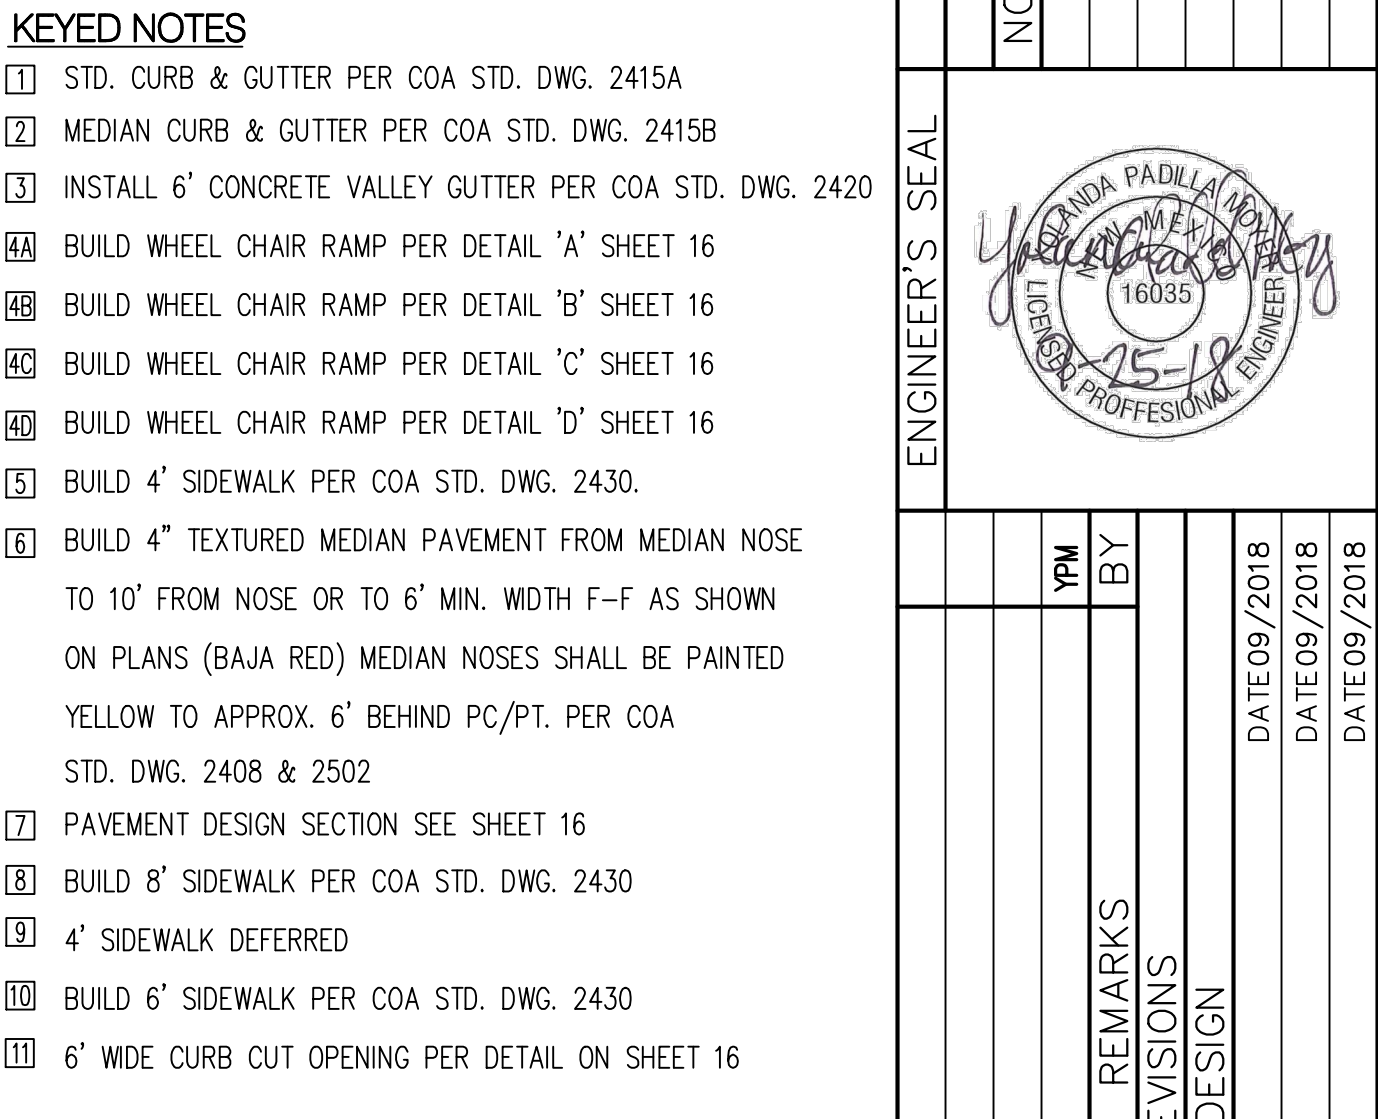
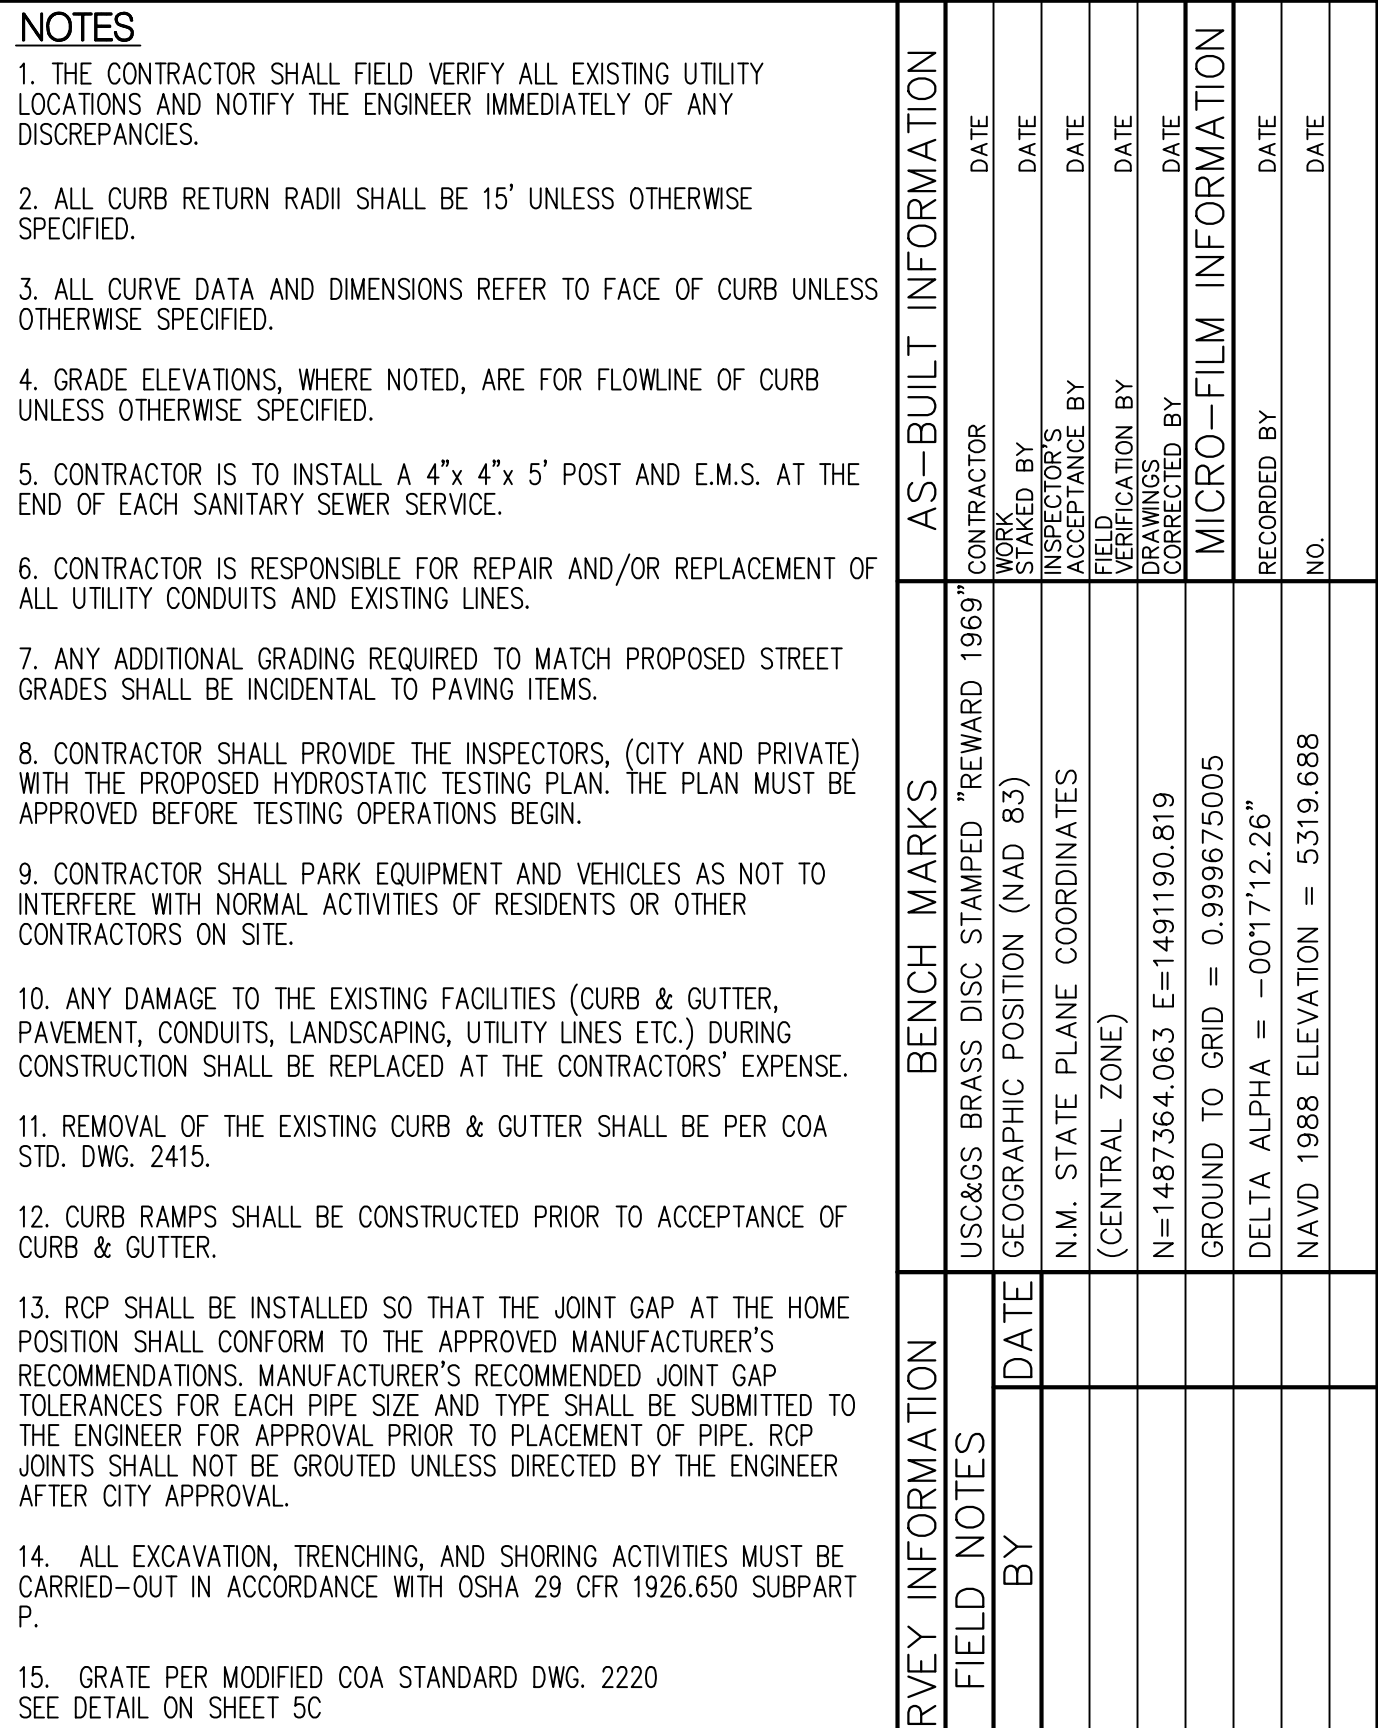
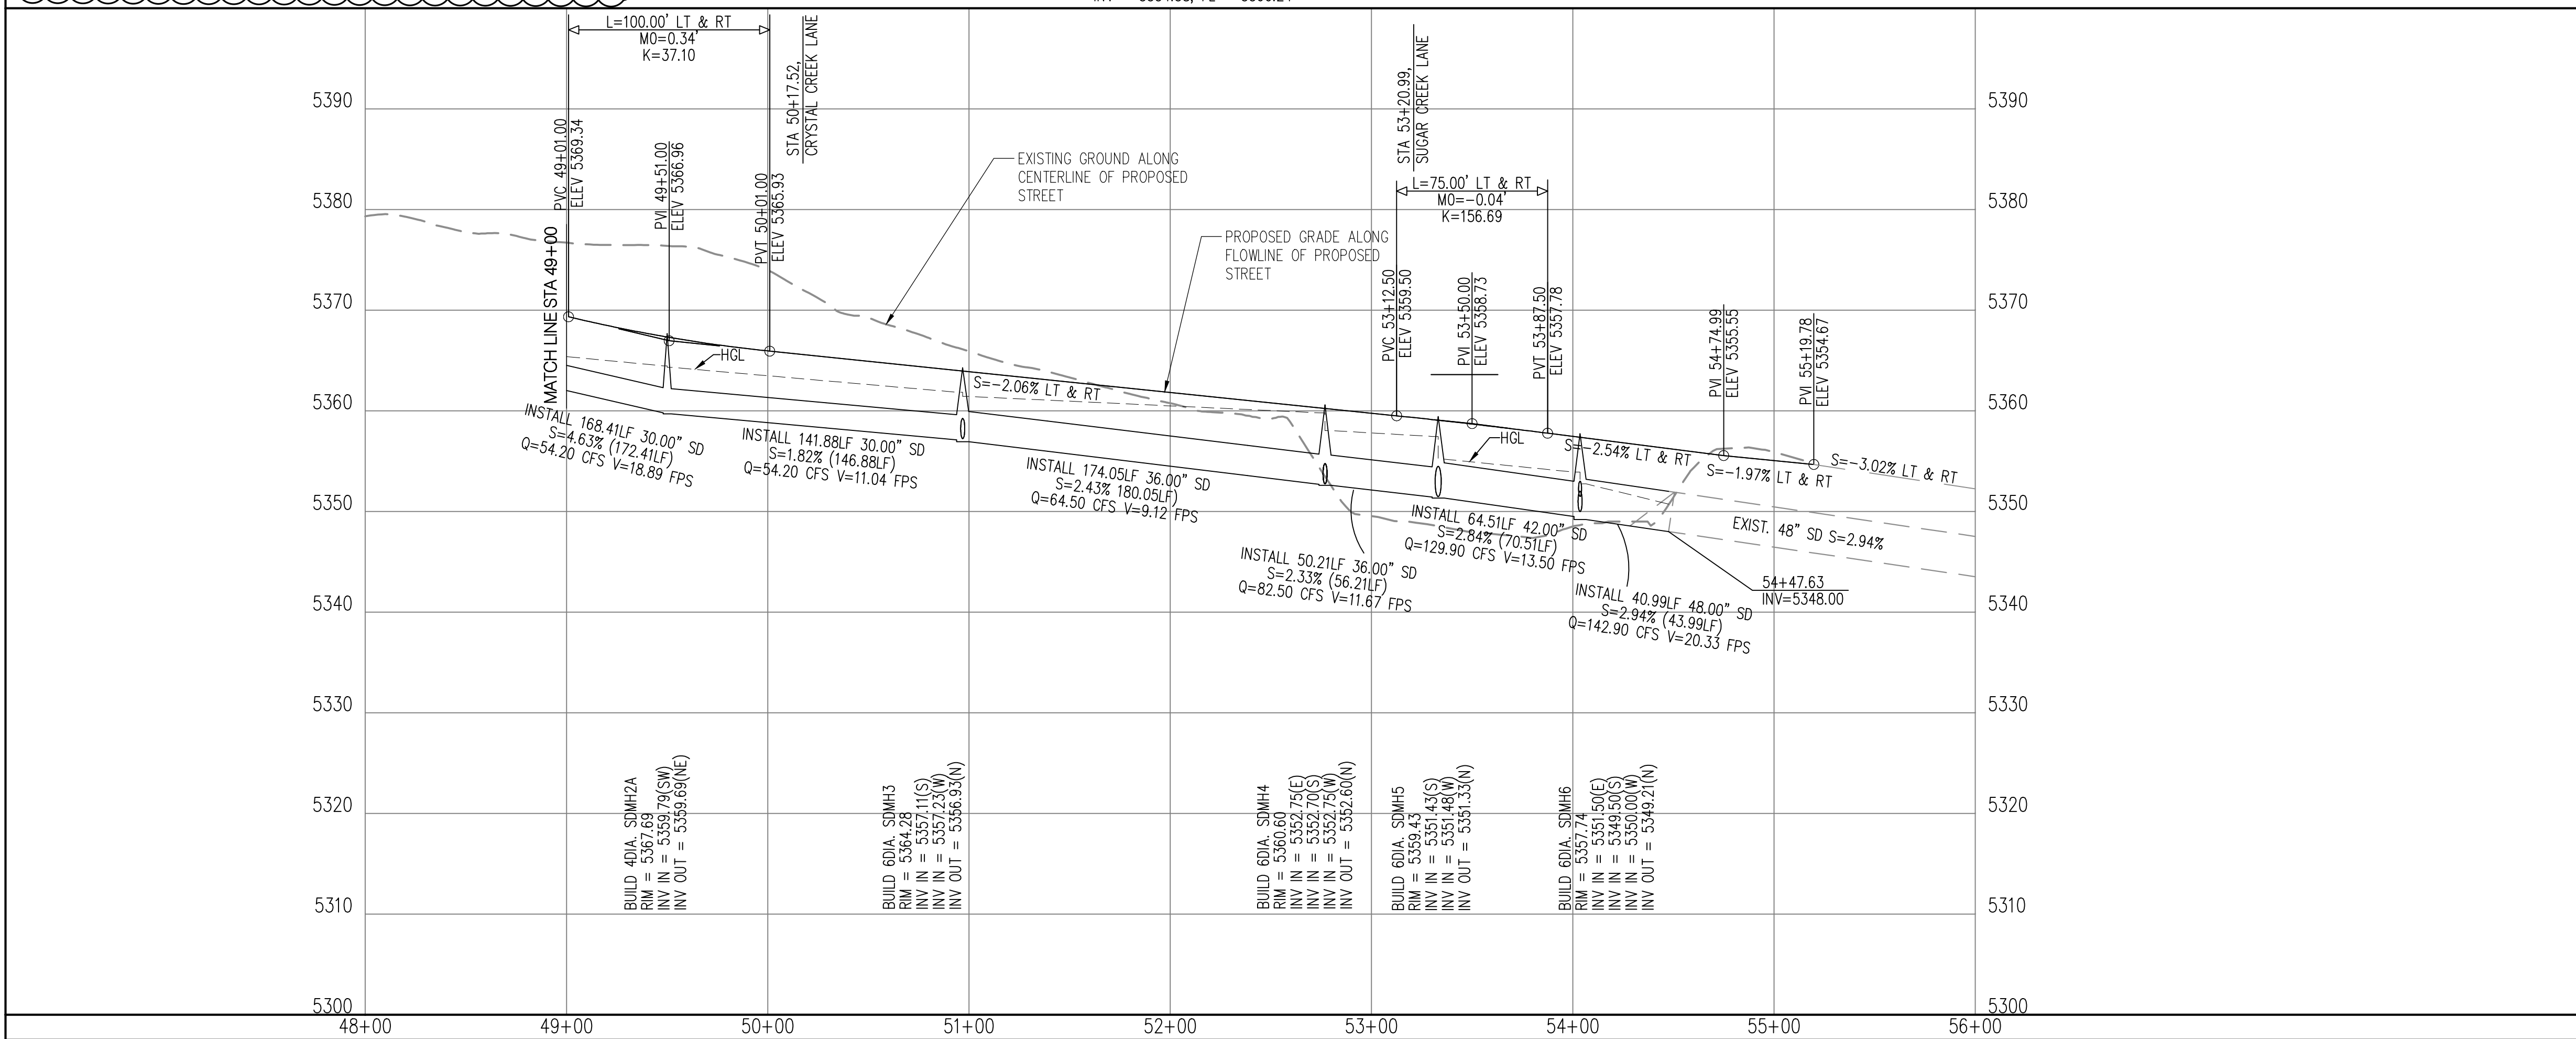
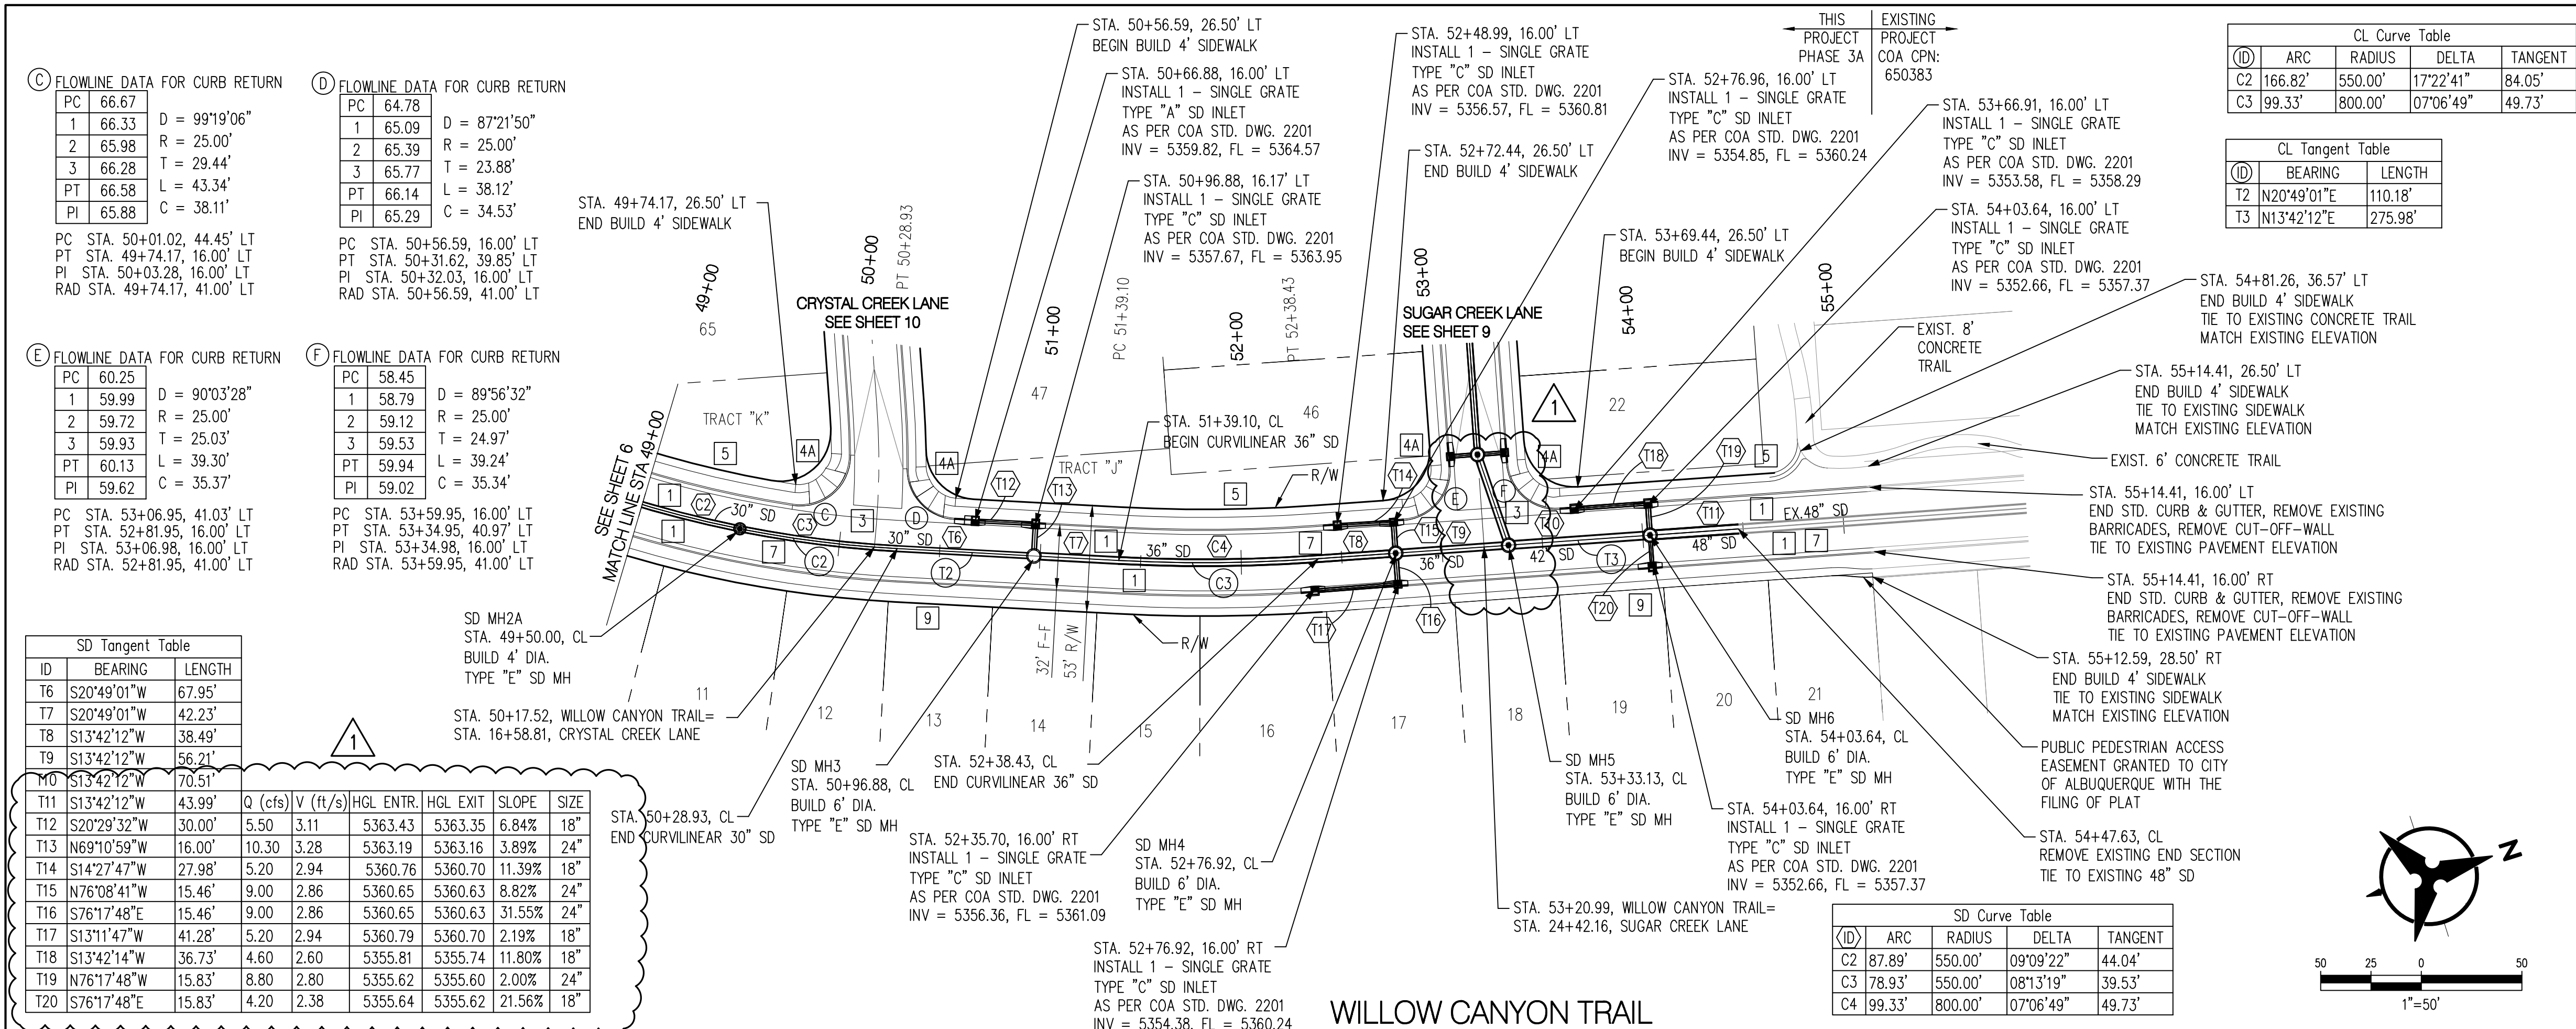
1. Build note specifies a 1.25' x 4.5' opening and detail specifies 1.25' x 4.0 foot opening.
2. For the upstream inlet: it is not clear there is enough vertical space to construct the center support and the grate frame.

TOG is at 86 and the invert is at 84.16. Hole is 1.25 ft high. This leaves 0.59 feet for the center support and grate frame. Center support is 5" plus 4" for the grate frame is 9" or 0.75 feet.

3. It is not clear there will be enough structural support above the hole in the back of the inlet.
4. For the downstream inlet: The pipe will have to be offset (not centered) so that the center support can be constructed.

TOG is at 87.64 and the invert is at 84.06.  $87.64 - 84.06 = 3.58$ . The pipe is 30" plus 3" wall = 3 feet. This leaves 0.58 feet for the center support and grate frame. Center support is 5" plus 4" for the grate frame is 9" or 0.75 feet.

6. Please remove the word "Temporary" from "Temporary Pond".
